Summary of Written Representation for Deadline 3 on behalf of N J Bacon Farms, Ward Farming Ltd, A W Bacon Will Trust and Nat & India Bacon

Our written representation for Deadline 3 include the following concerns:

DRAWING TITLE:
 FIGURE 1.1
 WESTLETON MARSH HARRIER COMPENSATORY HABITAT LOCATION

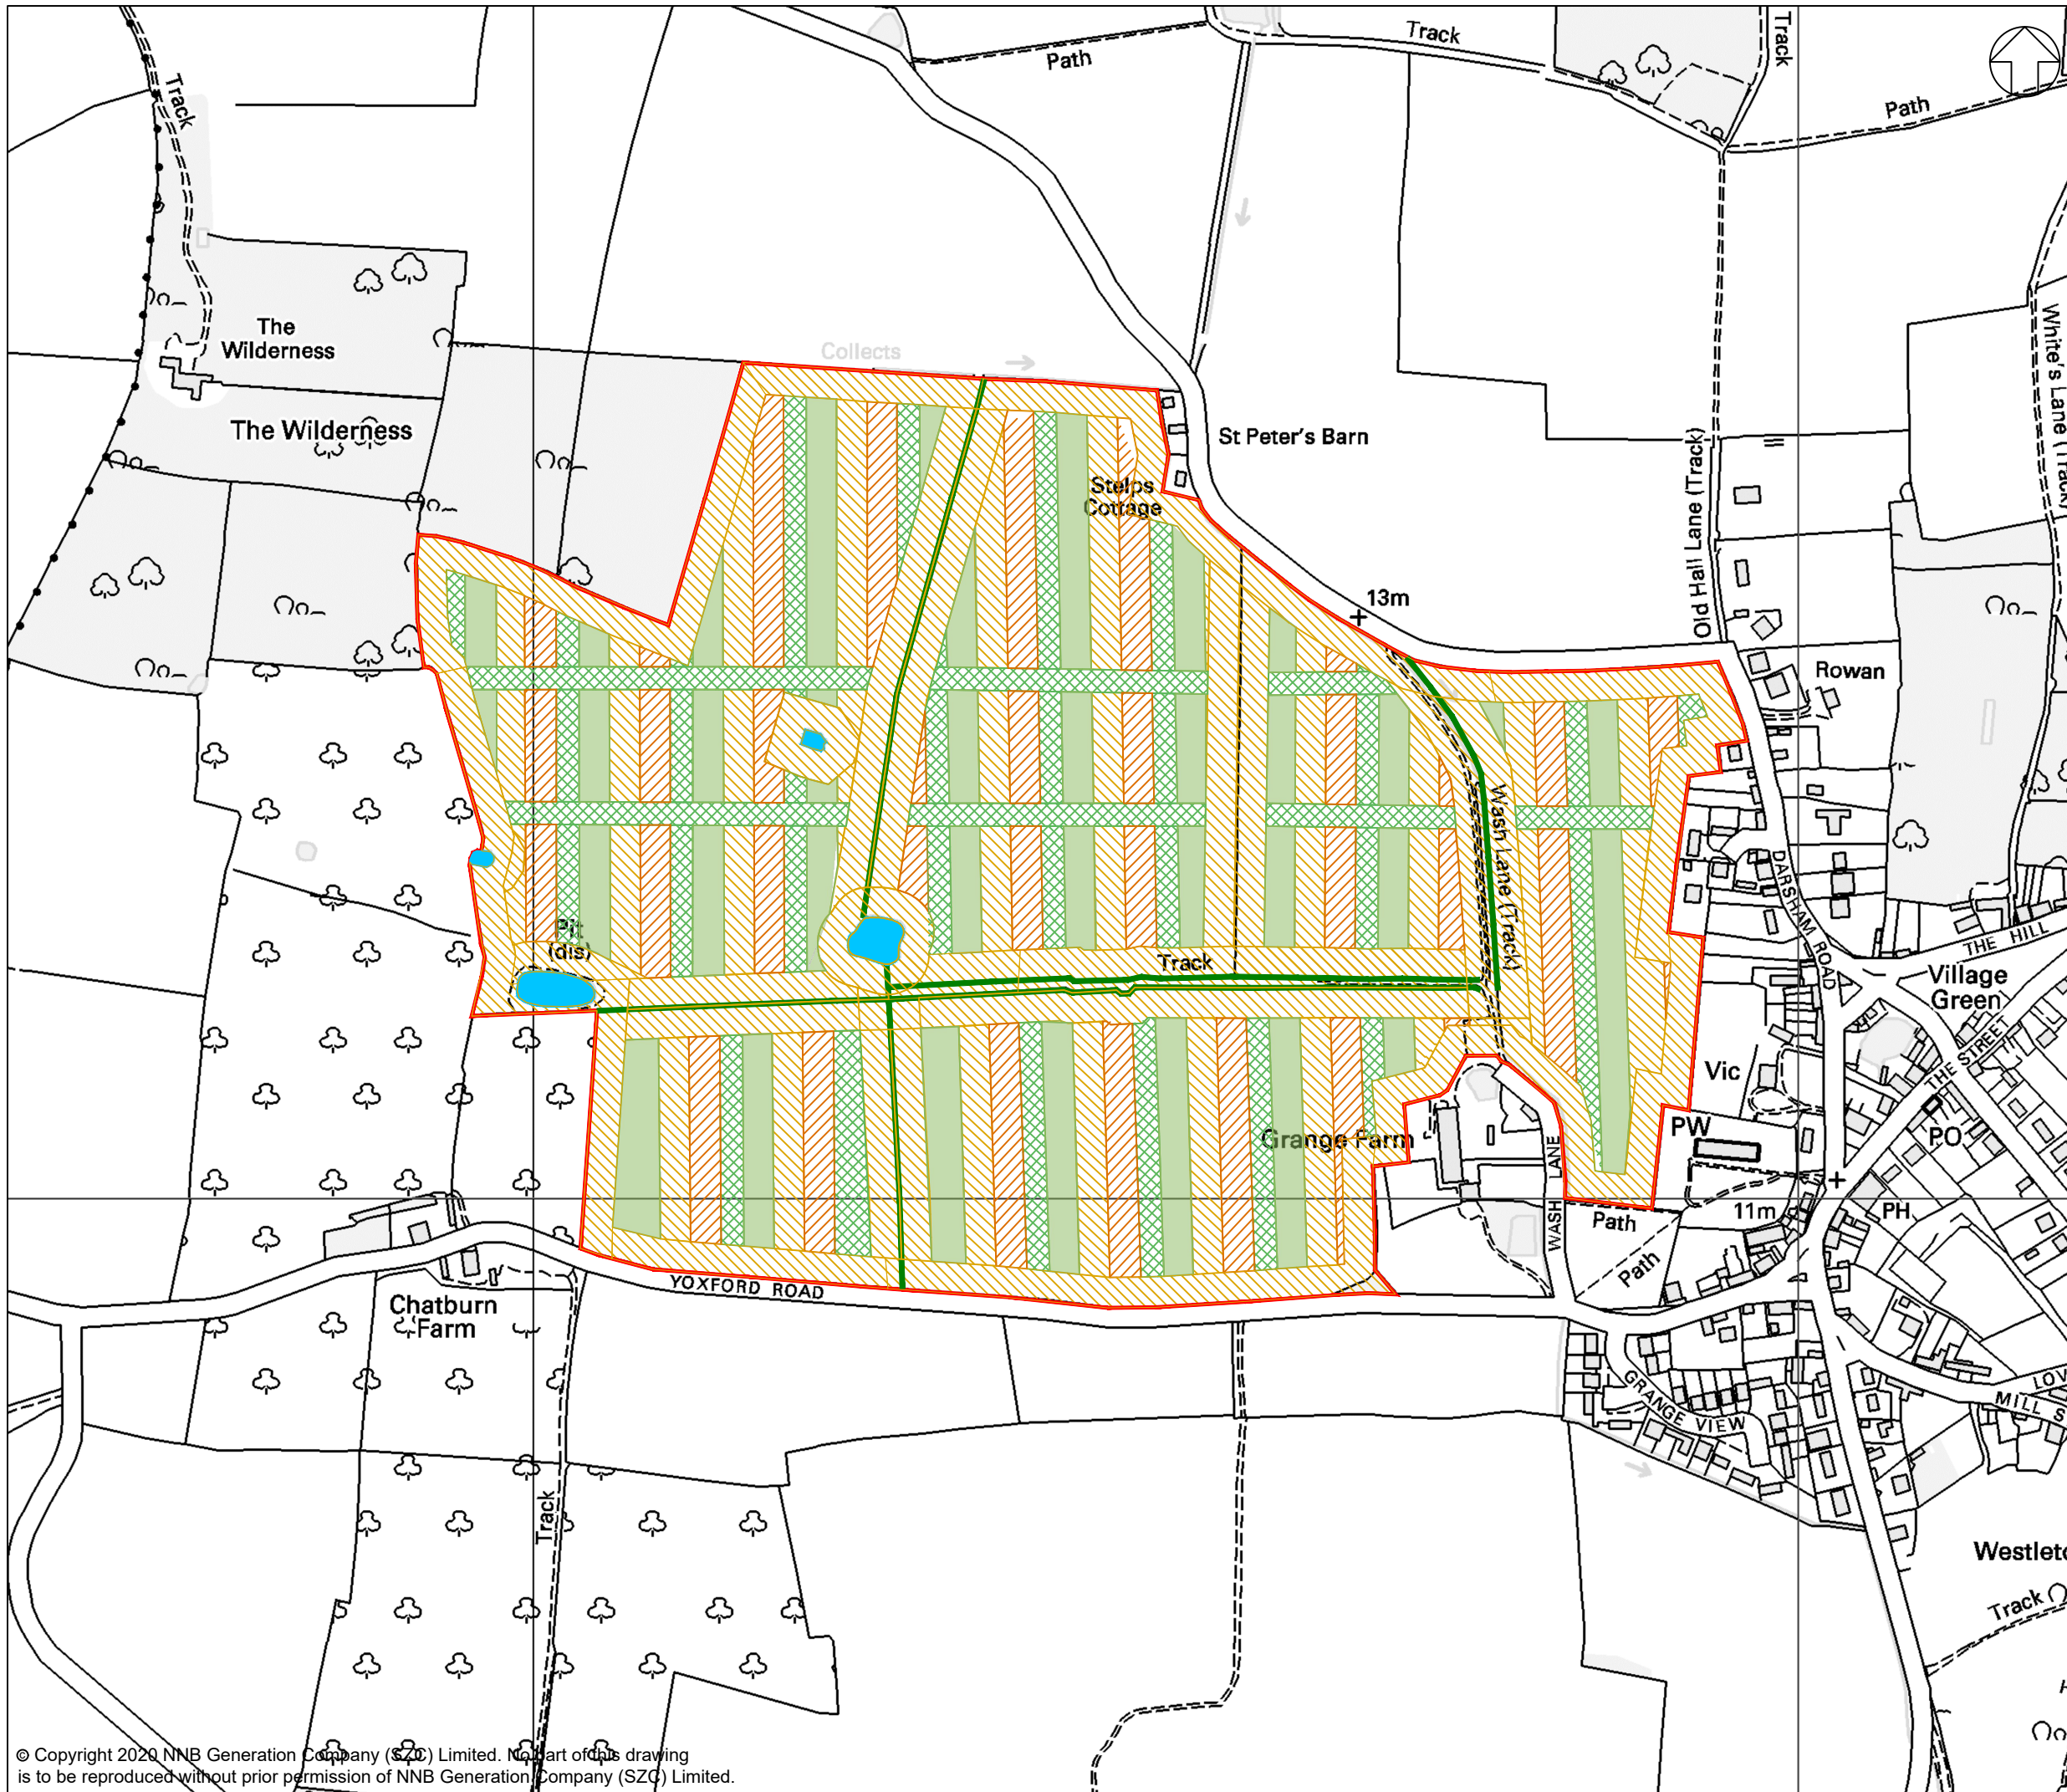
The suitability and criteria for selection of the marsh harrier habitat site at Grange Farm, Westleton
